**From:** Douglas Sherwood  
**To:** Jean Fraser  
**CC:** Alex Jaegerman; Ann Machado; Barbara Barhydt; Craig Worth; David Ono...  
**Date:** 1/22/2015 4:07 PM  
**Subject:** Re: Sign Permit Application \_ PPS District Office 351-353 Cumberland  
**Attachments:** Burr Signs Exterior entrance frame Signage Proof 12-15-14.pdf; 100\_2056.jpg; 100\_2058.jpg; 100\_2059.jpg

>>> Jean Fraser 1/22/2015 2:38 PM >>>  
Ref Sign Application #2015-00052

I understand that Ann Machado in Zoning has determined that the proposed signs do not meet the Sign Ordinance requirements of the B3 zone and now this is being treated as an appeal to the Planning Division.

Site plan 2 - Descriptions

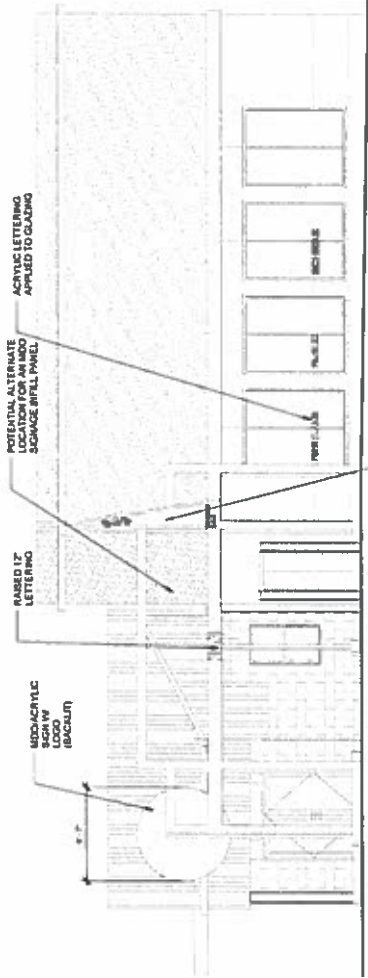
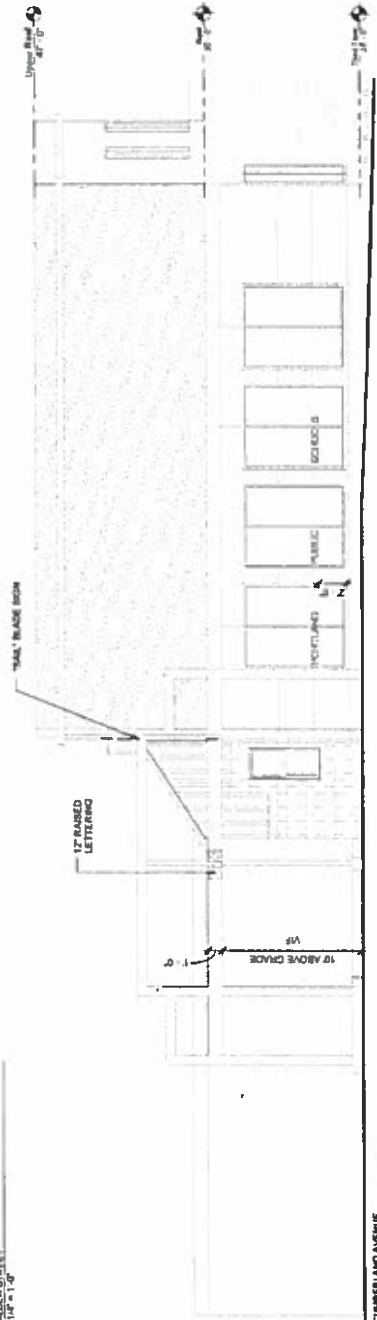
For the panel with logo below the larger panel, please confirm the paint color and logo color, the size of the vinyl logo (is 6'7" the diameter?) and confirm that this will not have any lighting;

Regarding the circle logo on the wall above the vestibule, could you confirm the colors and that only the outline ring and the ship/water will be back lit;

2. The small panel below the enclosed sign will fit exactly edge to edge the existing outside column spacing (55 to 56 inches) and be 96 inches high (again the proof is to scale). The 0.080 aluminum panel will be painted True/Pure Blue and the applied cut vinyl either brushed aluminum if back lit and white if facelit. (Note: Would you or other members of the Planning Department have a desired preference?) The logo on this panel would be 44 inches in diameter and would have no lighting (single face panel in front of columns).

3. The logo over the main entrance (set well back from the road) will be acrylic with applied vinyl graphic in an aluminum can attached with Jewelite trim cap for easy servicing. Our plan was to back light the entire sign, but we could limit it to the trim and ship itself.

Proposed Free Standing Sign w/ Panel

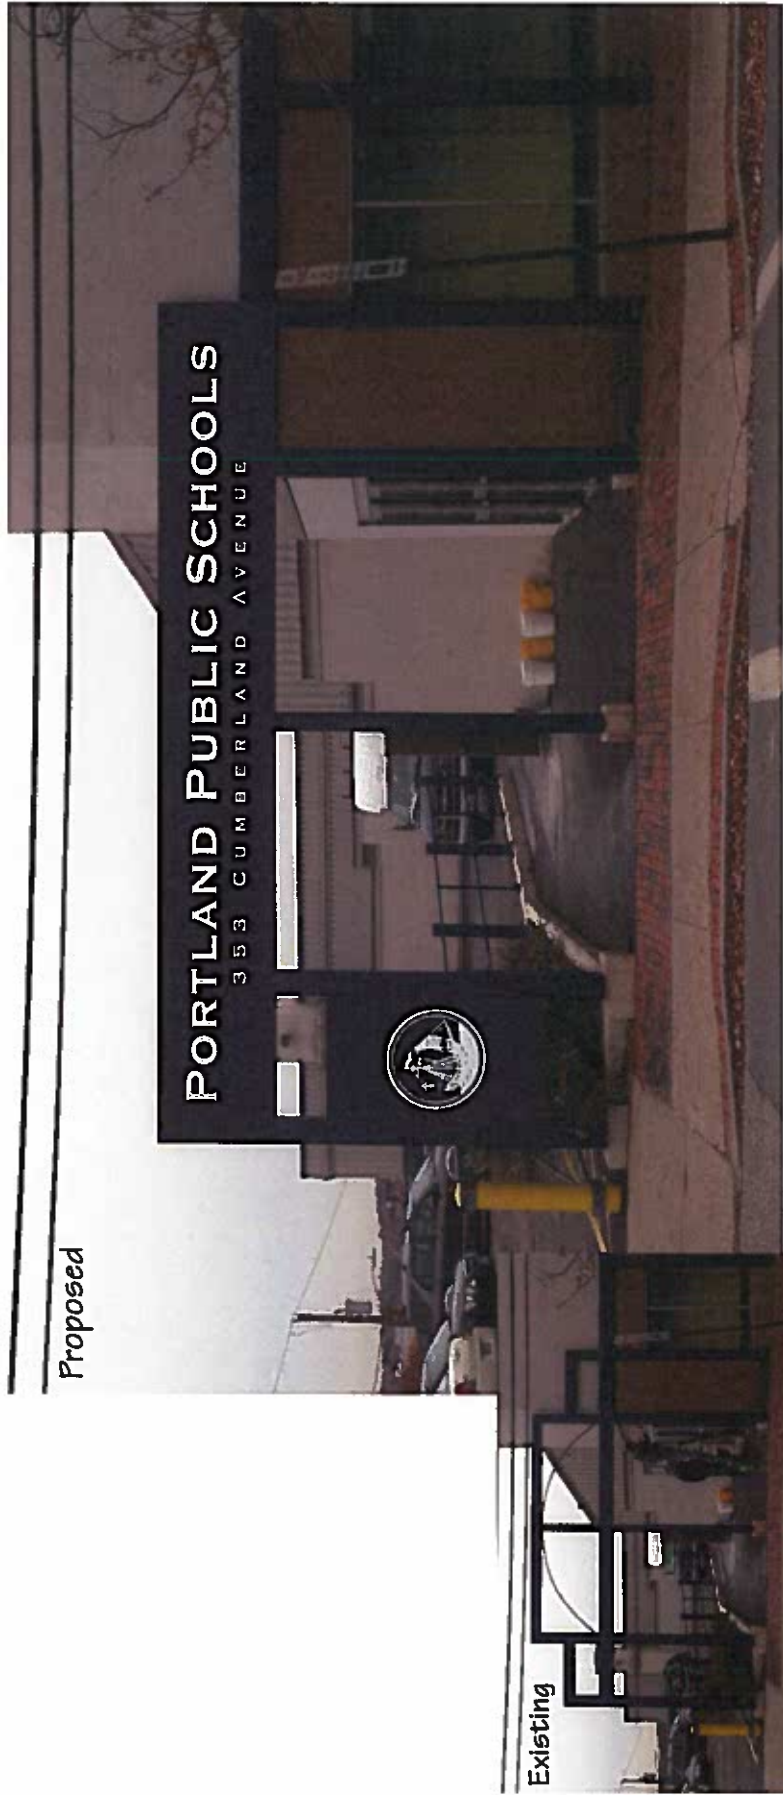
Please provide a scaled elevation of the proposed 4' X 31' panel showing how it will look from the side and front and clarifying materials, colors, dimensions of the letters etc;

1. The letters on the 4' by 31' sign proposed for the top of the existing frame are centered and to scale (see attached proof). The larger capital letters (P,P,S) in the "PORTLAND PUBLIC SCHOOLS" line are 13.25" high and smaller caps are 10.75". The numbers plus the letters C and A on the "353 Cumberland Avenue" line are 5.5" high and the remaining letters 4.5" high. The aluminum header panel will be fully enclosed, painted to match our letterhead pantone like the rest of our site trim color (Glidden True/Pure Blue, #62BB 081369 (order #A 1483, see attached photo of existing trim). The original request was brushed aluminum letters and back lit, but we may go with face lit. Backlit letters would have 1/2 inch standoff and be about 2.5 inches in front of the frame. Facelit letters (which could be brushed or clear) would be surface mounted and stand out 2 to 3 inches. The width of the enclosed frame is intended to match the width of the existing frame (see attached photos ...#2058 and....#2059) which about 8.5 inches.

As per my voice mail earlier this week, we have opted to go with brushed aluminum letters in our standard letterhead style font, but, instead of being facelit as shown on Burr Signs' proposal, the letters will be backlit. Hopefully, this is all you need to give us the green light and issue the permit.
